Development Control
Ribble Valley Borough Council

Application no: 2026/0140

Address: Rose Hill Farm Whalley Old Road Billington BB7 9JF

Proposal: Proposed demolition of existing dwelling and replacement with one new dwelling (self-build), outbuilding and garage together with new access from Whalley Old Road.

Proposed Site Plan
Scale 1:500

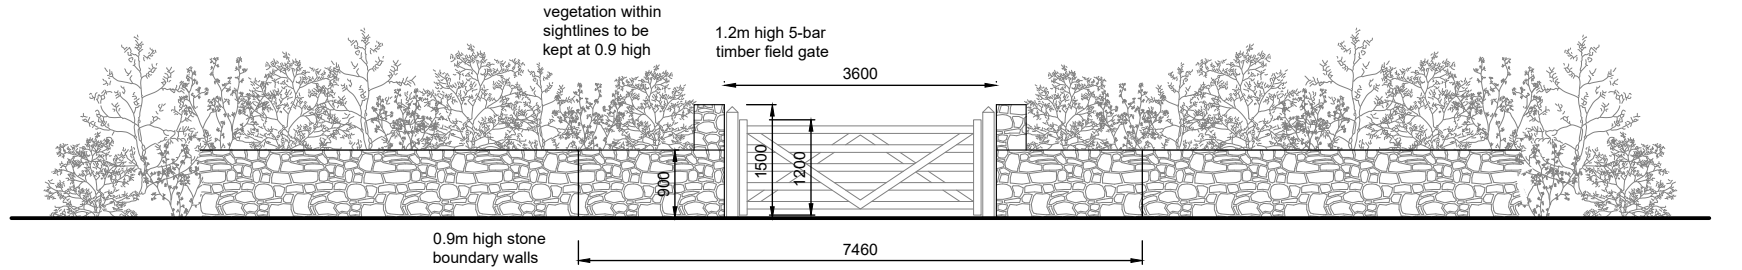
The new access will need to be constructed by way of a section 278 agreement to ensure that it is tied into the existing carriageway. This will prevent damage to our highway and the applicant's driveway. It would be preferable if the first 5m was reasonably level to ease the access to the highway and it is expected that the first 10m of the access will be constructed in-line with Lancashire County Council's Specification for Construction of Estate Roads.

Additionally, a paved area should be provided for the storage of wheelie bins prior to collection.

The plans show that FP-03-06-026 are to be diverted this will require a legal order and process which can take a number of weeks to reach completion.

a) Highway works constructed prior to occupation.

No part of the development hereby approved shall be occupied or opened for trading until all the highway works have been constructed and completed in accordance with a scheme that shall be submitted to and approved by the Local Planning Authority in consultation with the Highway Authority.

b) New road built to base course level.

The new estate road / access shall be constructed in accordance with Lancashire County Council's Specification for Construction of Estate Roads to at least base course level before any development takes place within the site.
